Application Reference Number:	2025/0265		
Application Type:	Householder		
Proposal Description:	Erection of attached garage to side and rear of dwelling (retrospective)		
Location:	242 Darton Lane, Mapplewell, Barnsley, S75 6AJ		
Applicant:	Mrs Helena Bentley		
Third-party representations:	Four	Parish:	None
		Ward:	Darton East

This planning application seeks householder planning permission for the erection of attached garage to side and rear of dwelling. It is noted the application is retrospective.

Drawing Title:
PLAN, ELEVATIONS
& SITE PLANS AS
PROPOSED
DEC 2025

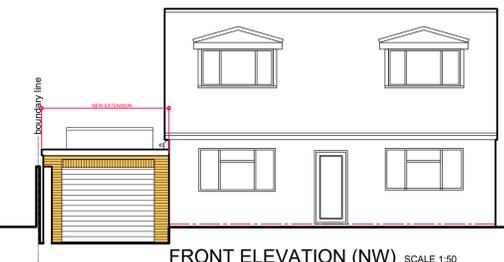
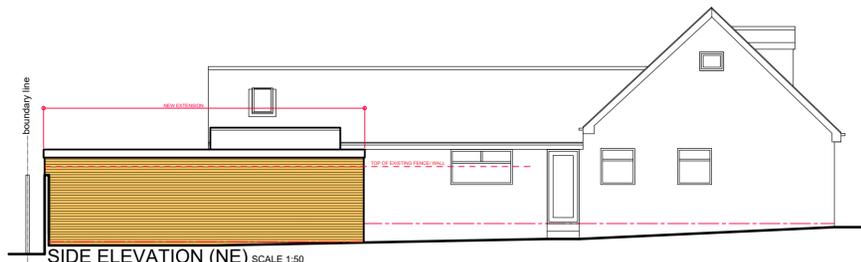
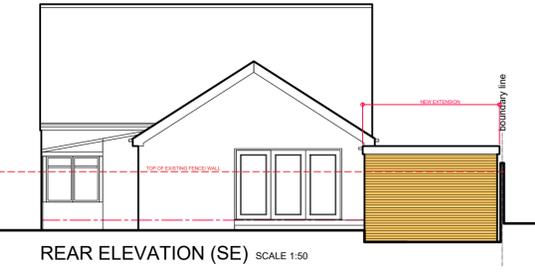
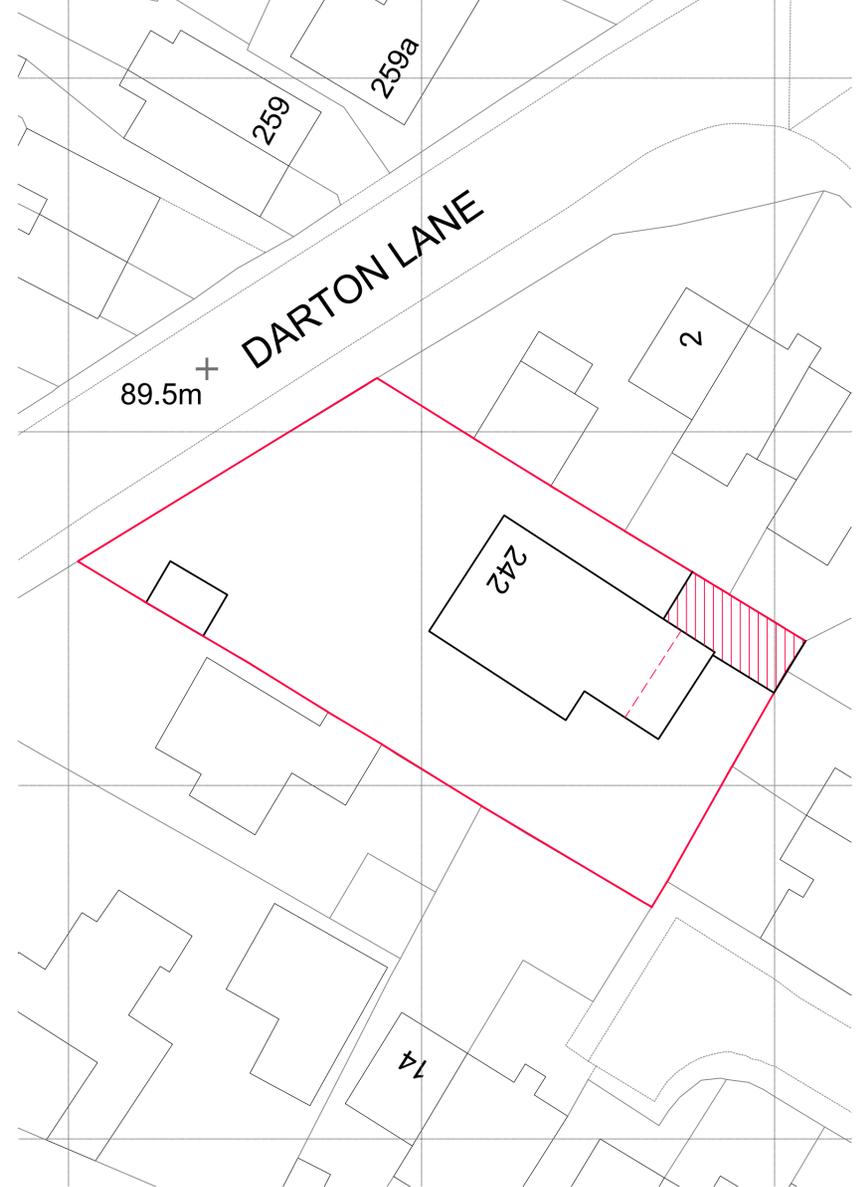
The applicant seeks approval for the erection of a single storey side rear extension to form an attached garage. The garage has a length of 8.9 meters and a width of 3.55 metres. The garage features a flat roof with a total height of 3.3 meters. The materials used will be matching brickwork and with a grey roof membrane.

The SPD states that *“extensions to the rear of detached houses will be considered on their design merits and where no adjacent properties are affected”*. The design is relatively in keeping with the existing dwelling and the extension has modest projections of 4.65 metres to the rear and 3.55 metres to the side which is less than two thirds the width of the dwelling.

Equally, it is not considered overbearing due to its restrained size and massing. This weighs significantly in favour of the proposal. Overlooking will be limited even with the addition of patio doors to the side elevation as they look onto the host dwelling’s garden area. This weighs modestly in favour of the proposal.

The SPD states that *“detached garages should be single storey structures and the eaves height should not normally exceed 2.5 meters from ground level”*. The proposed garage has a flat roof with a maximum height of 3.3 metres. Although in this circumstance the eaves would exceed the recommendation this is in favour of a structure that is modest in total height due to the use of a flat roof. This weighs modestly in favour of the proposal.

The SPD states that *‘materials should normally be of the same type, colour and texture to the existing house or as close a match as possible’*. In this case, the proposed materials for the extension will partially match the host dwelling with matching brickwork being used along with the membrane for the flat roof. The brickwork will be the most prominent in the street scene and this harmonies with the existing dwelling. This weighs moderately in favour of the proposal.

The garage extension utilises a flat roof. Flat roofs are not a supported roof type due to flat roofs being an inferior form of construction however in this circumstance is it acceptable as it set to the rear of the dwelling and the proposed height of the roof is not excessive, therefore the visual amenity of the area would be maintained, in accordance with Local Plan Policies D1. This weighs moderately in favour of the proposal.
